CITY OF ALBUQUERQUE

RE: **T-Mobile Store**
5350 Academy Rd. NE
Grading and Drainage Plan
Engineers Stamp Date 8/13/15 (E18D030A)

Based upon the information provided in your submittal received 8/14/15, this plan is acceptable for Grading Permit and Building Permit.

Project Number 2014038
Drawn By JW
Checked JW
Issue Date August 13, 2015
Grading Plan

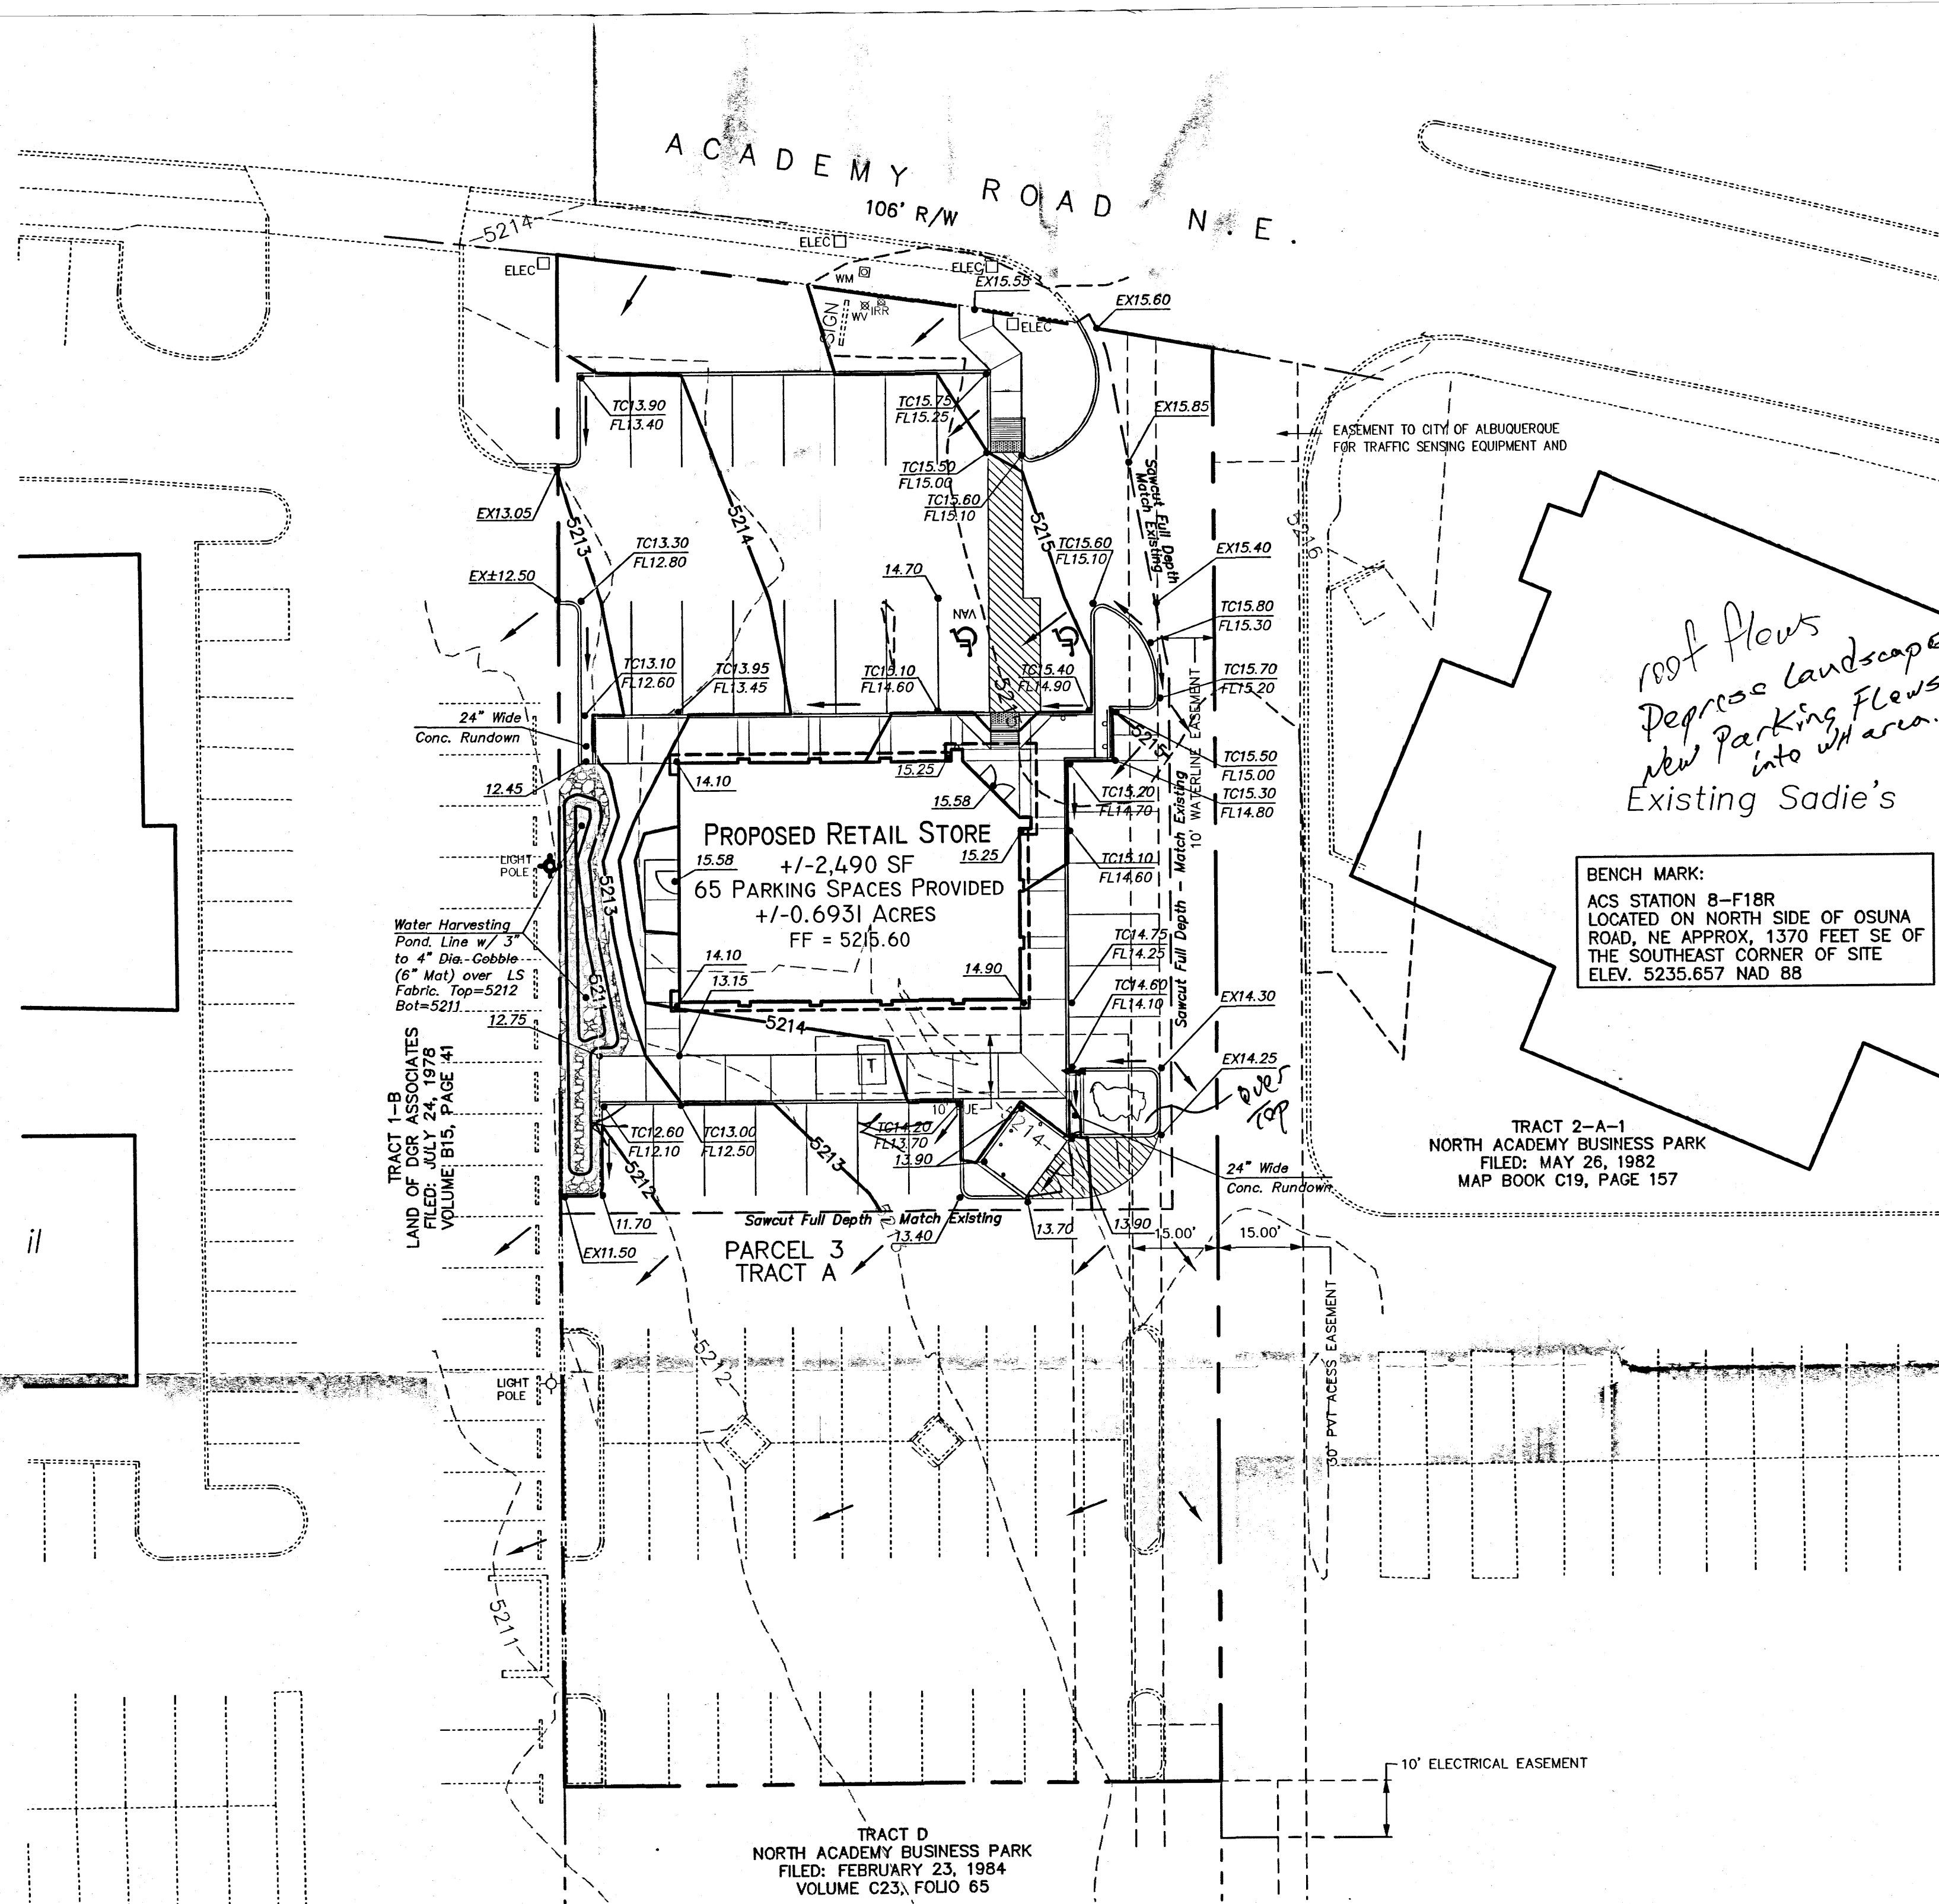
- Provide roof flows
- Depress all landscaping which is not within 10 feet of the building.
- It appears as though the flow in the east parking lot can be directed into the landscape area in the southeast corner which can then over top the curb, this can also be done with the new south parking spaces. The flows can be directed into the water harvesting area and lower this area by 6 inches.

- Roof Flow direction is now shown on the plan. The roof actually flows south and we realized that the flows were not being routed through the water harvesting pond. We have added a swale along the rear of the building with an 8" SD pipe that drains under the sidewalk and into the pond.
- In general, all new landscaped areas are being shown as depressed. Only two of the ponds accept impervious flows so we have only used those two ponds in our calculations.
- The landscape island at the southeast corner of the building has been modified to act as a water harvesting pond as you suggest. Great suggestion as we were previously showing this area to bypass the area in a flume.
